Sydney Grammar School

BCA Design Assessment Report

Weigall Sports Complex
SSDA 10421

Project: Weigall Sports Complex
 Document Type: BCA Design Assessment Report
 Report Number: P220_051-2 (BCA) LB

Drawing Title
BUILDING 01
SPORTS FACILITIES BUILDING
GENERAL ARRANGEMENT PLAN
GROUND

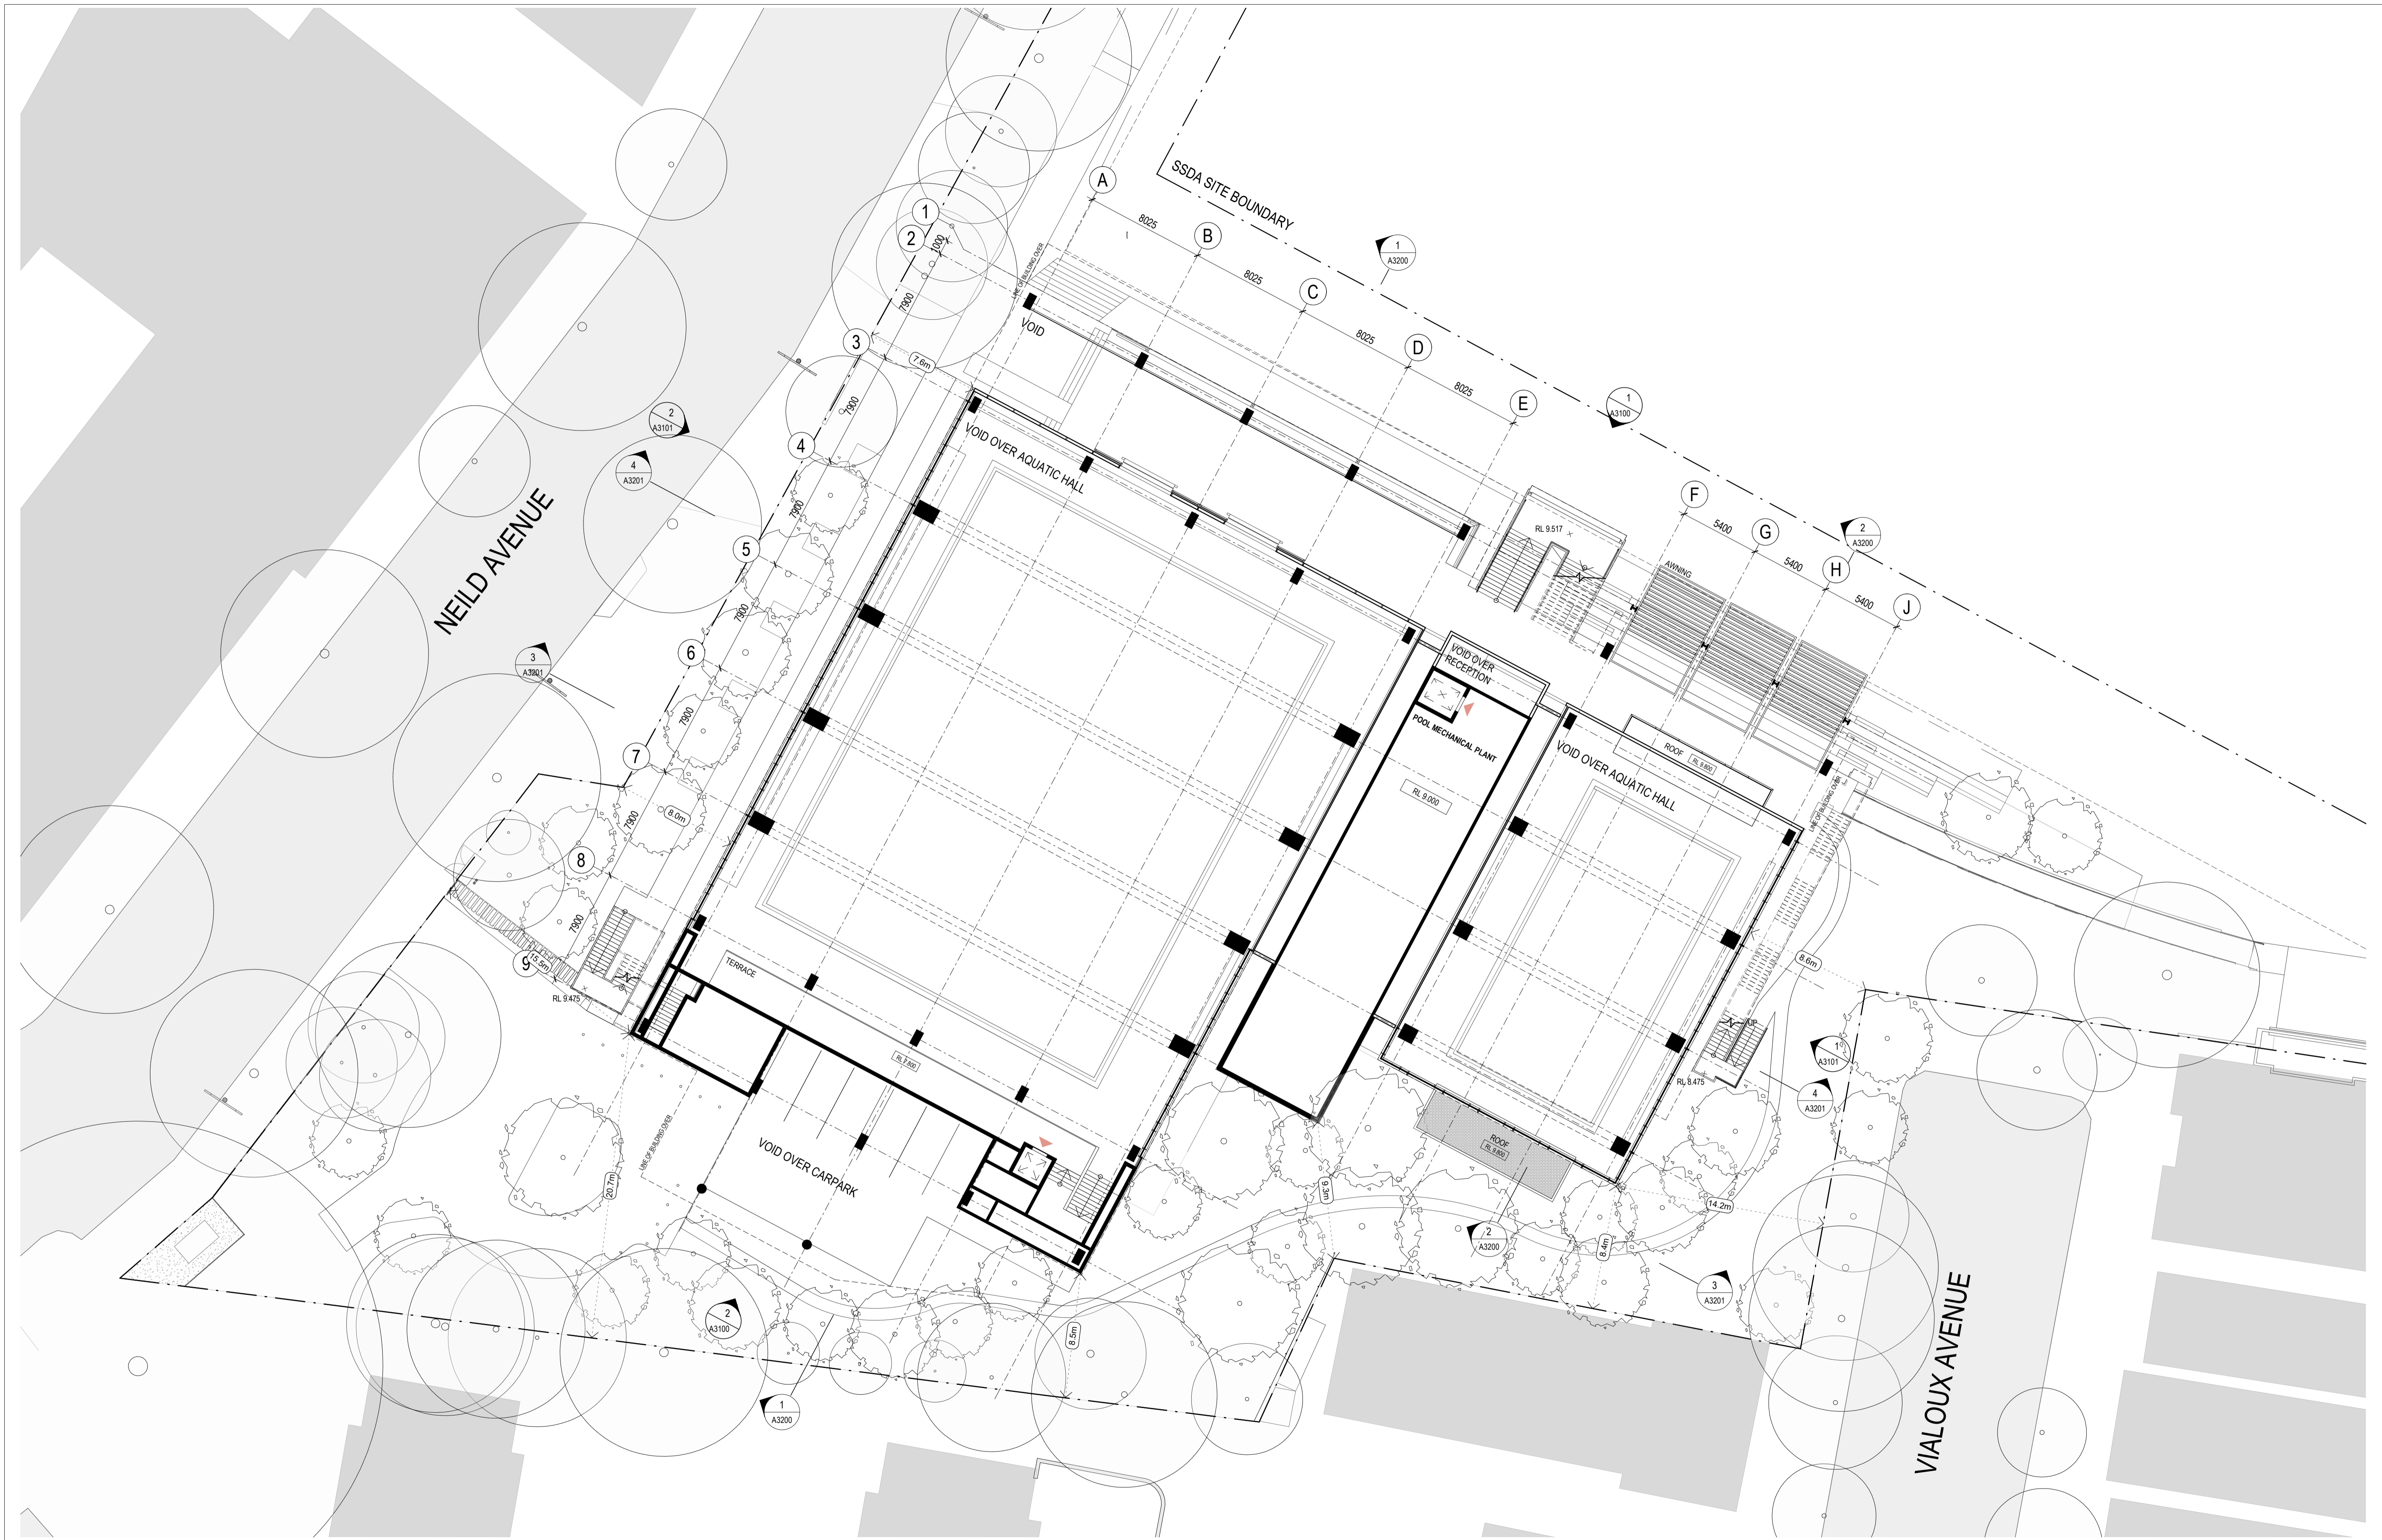
- iii. Basement
 - Travel distances of up to 44m to a single exit in lieu of 20m
- iv. Ground Floor
 - Travel distance to an exit of up to 27m choice in lieu of 20m from spectator area

- Ground floor - of up to 73m in lieu of 60m; and
- First floor - of up to 70m in lieu of 60m on the first floor of the sports complex.

- (i) Reconfigure floor plates to afford DTS travel distances; or
- (ii) Pursue a BCA Performance Solution / Fire Engineering Report which justifies that the current design complies with the relevant Performance Requirements.

- (i) Reconfigure floor plate to afford DTS distance between alternative exits; or
- (ii) Pursue a BCA Performance Solution / Fire Engineering Report which justifies that the current design complies with the relevant Performance Requirements.

Drawing Title
**BUILDING 01
SPORTS FACILITIES BUILDING
GENERAL ARRANGEMENT PLAN
MEZZANINE**

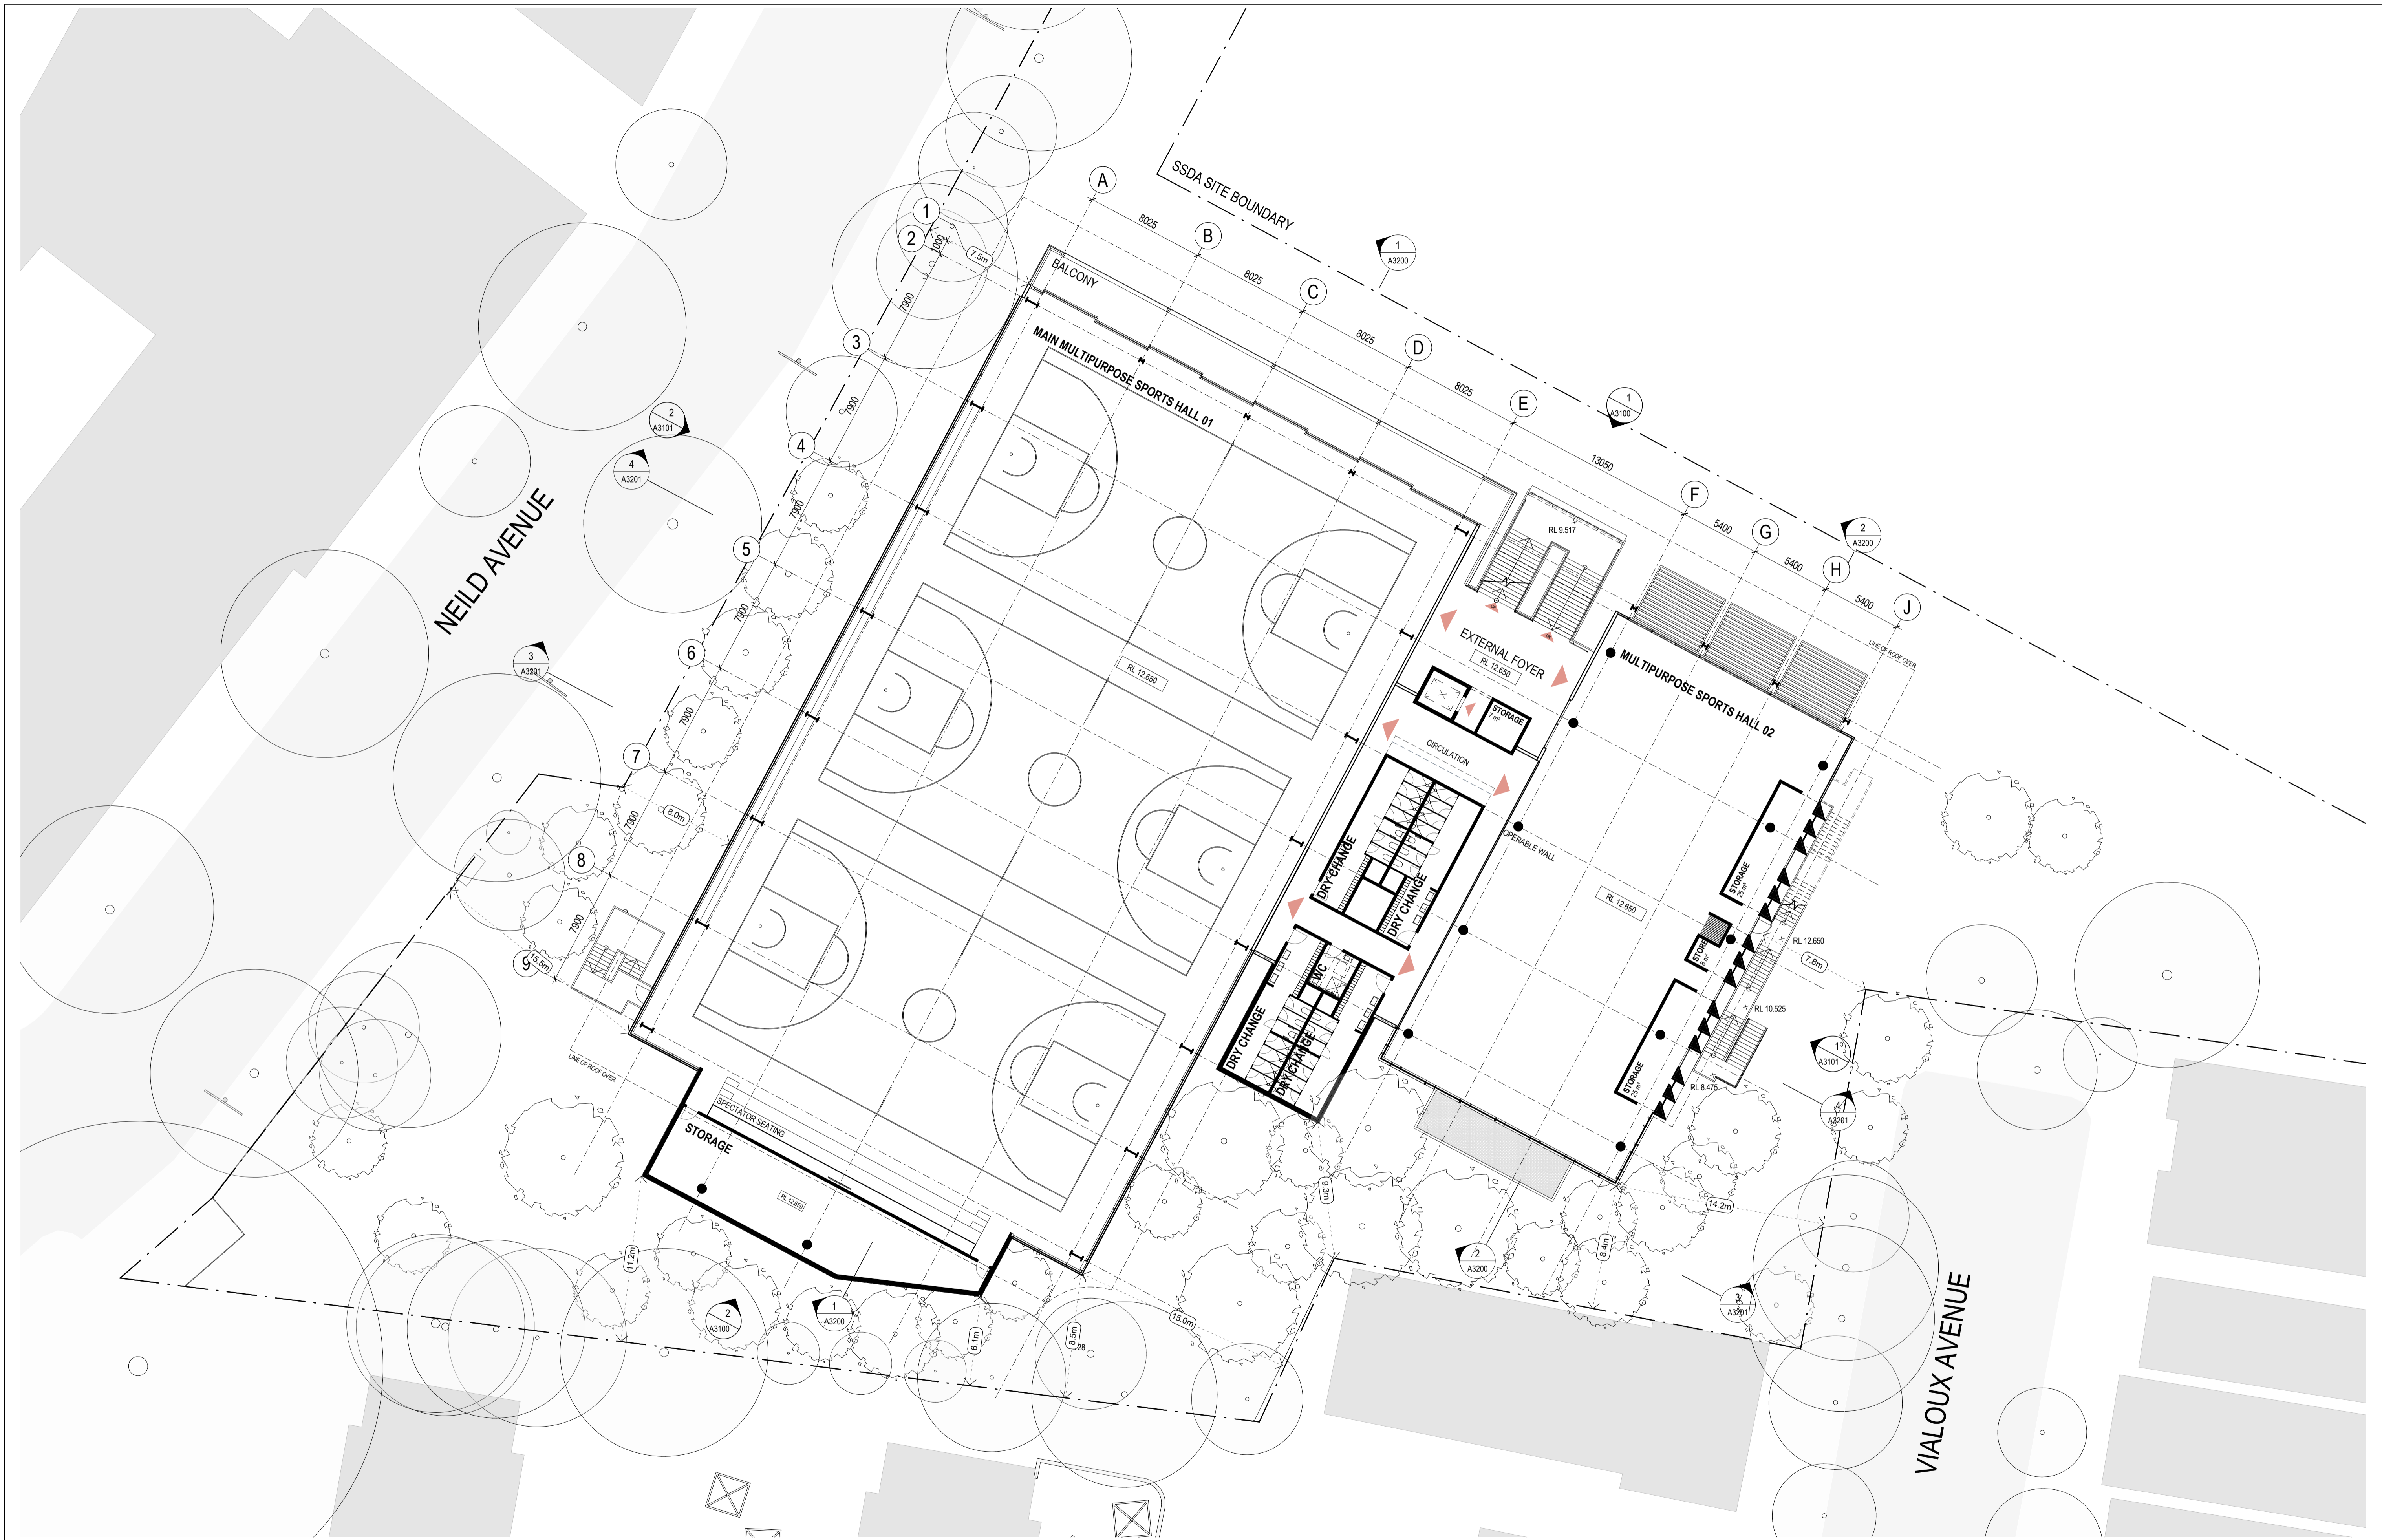
It is noted the terrace on the mezzanine level is only provided with a single exit, however it is understood less than 50 people would be accommodated and hence would achieve the concession under D1.2(d) (vi).
